Milton Orellana  
Project Manager | We Design and Build Dreams  
Atera Homes

RE: Chen residence Mercer Island City file 2102-184

What follows are the answers to posted comments with those original comments included as requested. Photographs of trees 518-9 included.

A102

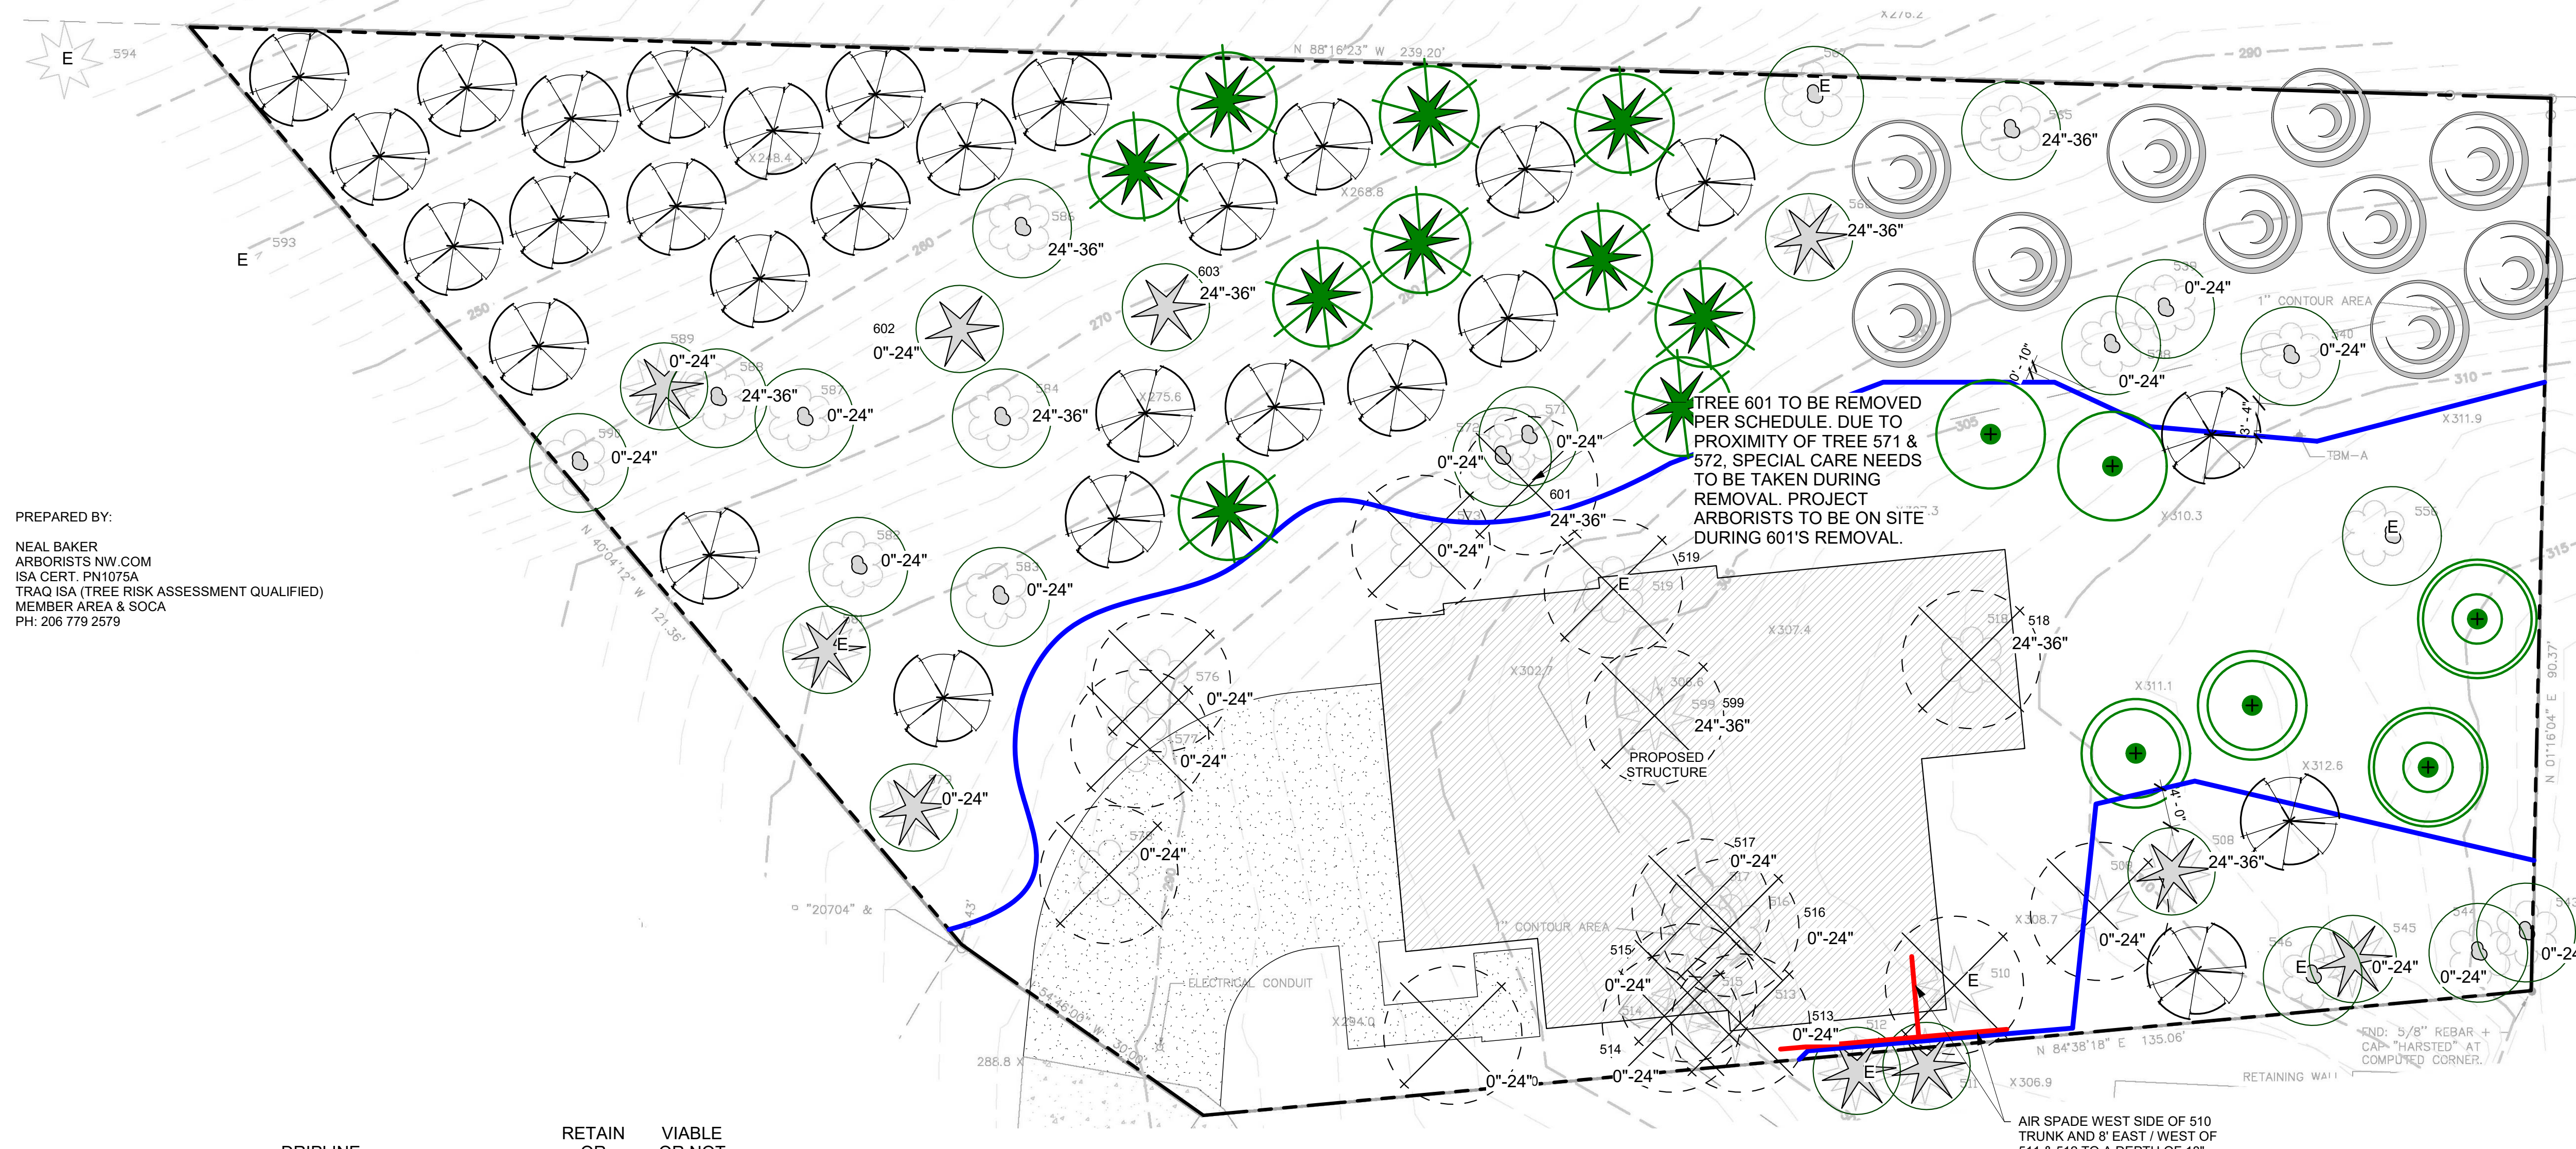
“4.(Repeat comment provided at Intake Review for Arborist/Civil/Architect) Tree 508 is exceptional and to be saved. However, tree protection is shown 8 feet from the face of the tree. This is inadequate and would probably result in the tree being damaged and removed. The Arborist gives the dripline at 40', is this a radius? It is unclear and this tree is not described in the report only a graphic on the plan. Tree 579's dripline is not to scale. Tree protection is shown 11' away while the dripline is 28' (assumed in radius). Confirm tree protection conforms with MICC19.10.080. The arborist must show my comment and then respond to it in a clear way, so I know they have received my comments. Any exceptional trees that would be damaged or removed need justification under MICC19.10.60.A.3. Tree protection needs to be shown at the critical root zone/dripline. No new grading that is shown on sheet A101 will be allowed within this tree protection area.”

Regarding Tree 508: Tree protection measures have been adjusted to show the full protection of the tree (sheet A102). The dripline for tree 579 has been re-scaled as required with appropriate tree protection locations. These are the responses to the comments below.
